CITY OF ALBUQUERQUE

September 17, 2012

Re: Paradise Bakery
Grading and Drainage Plan
Engineer's Stamp dated 8-29-12 (A14/D006)

GRADING AND DRAINAGE PLAN

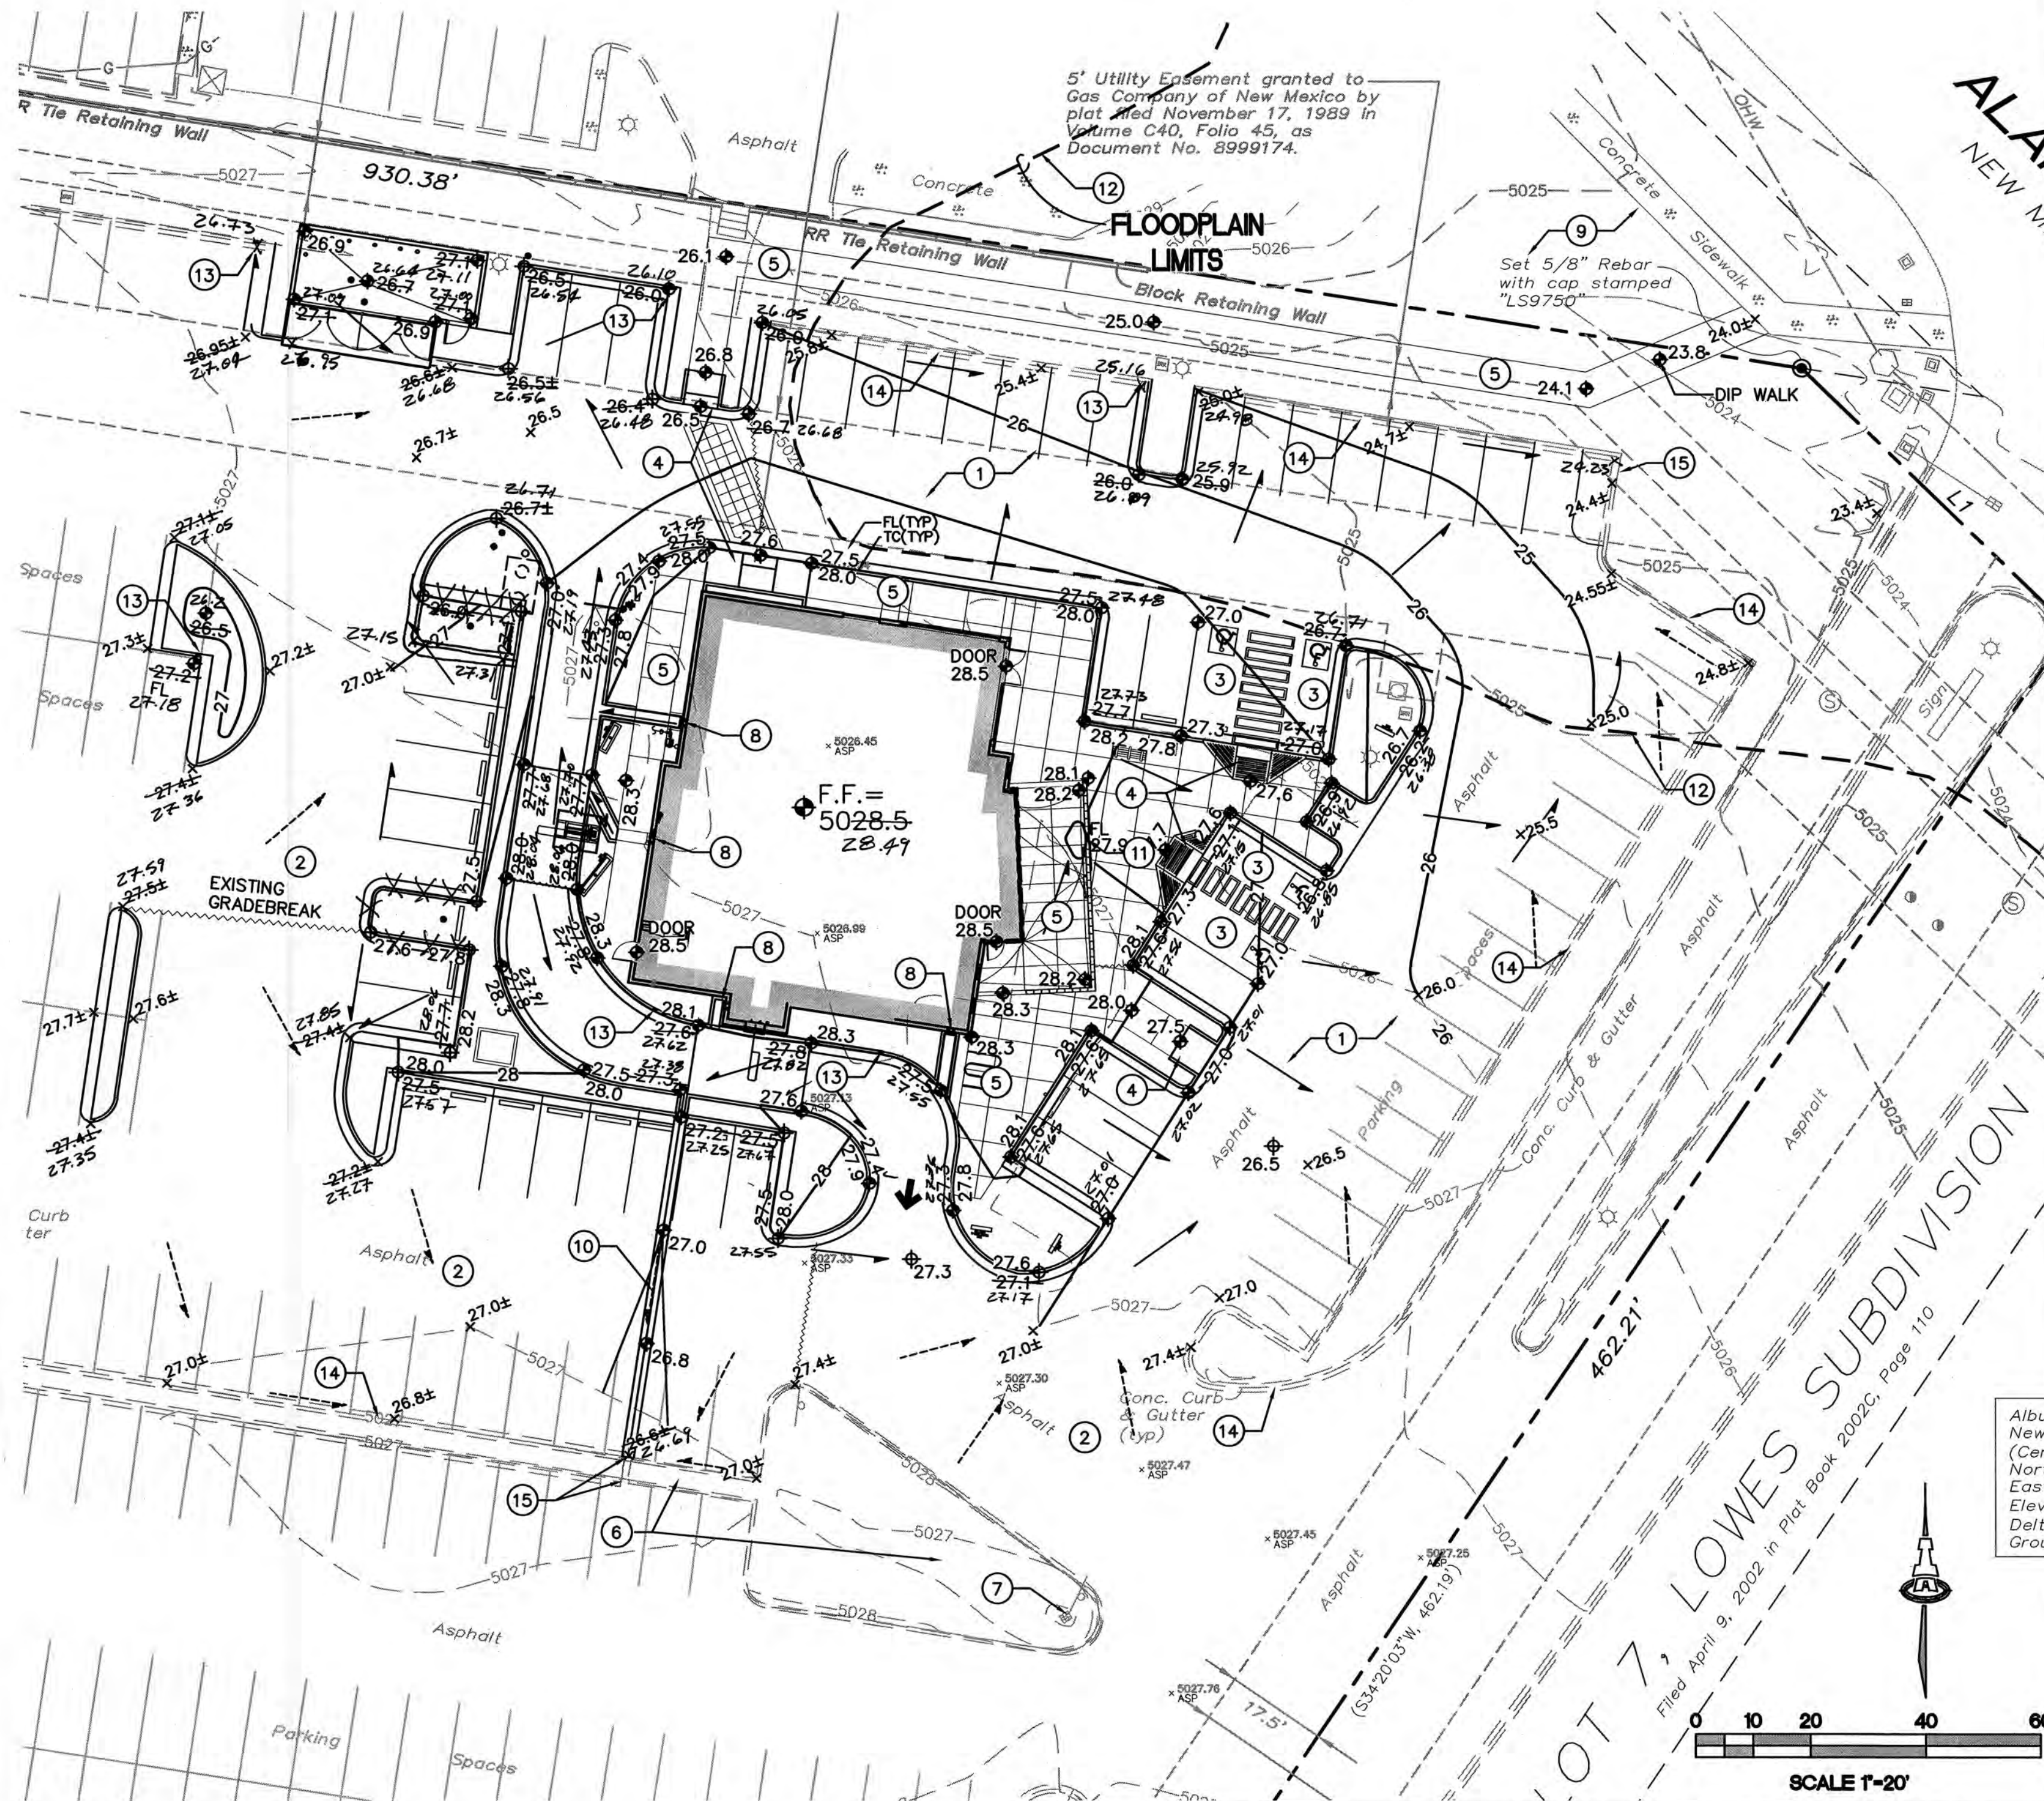
Based upon the information provided in your submittal received 9-4-12, the above referenced plan is approved for Grading Permit and Building Permit. Hydrology is requesting that all proposed landscape areas are depressed to retain/infiltrate the moisture that falls on them.
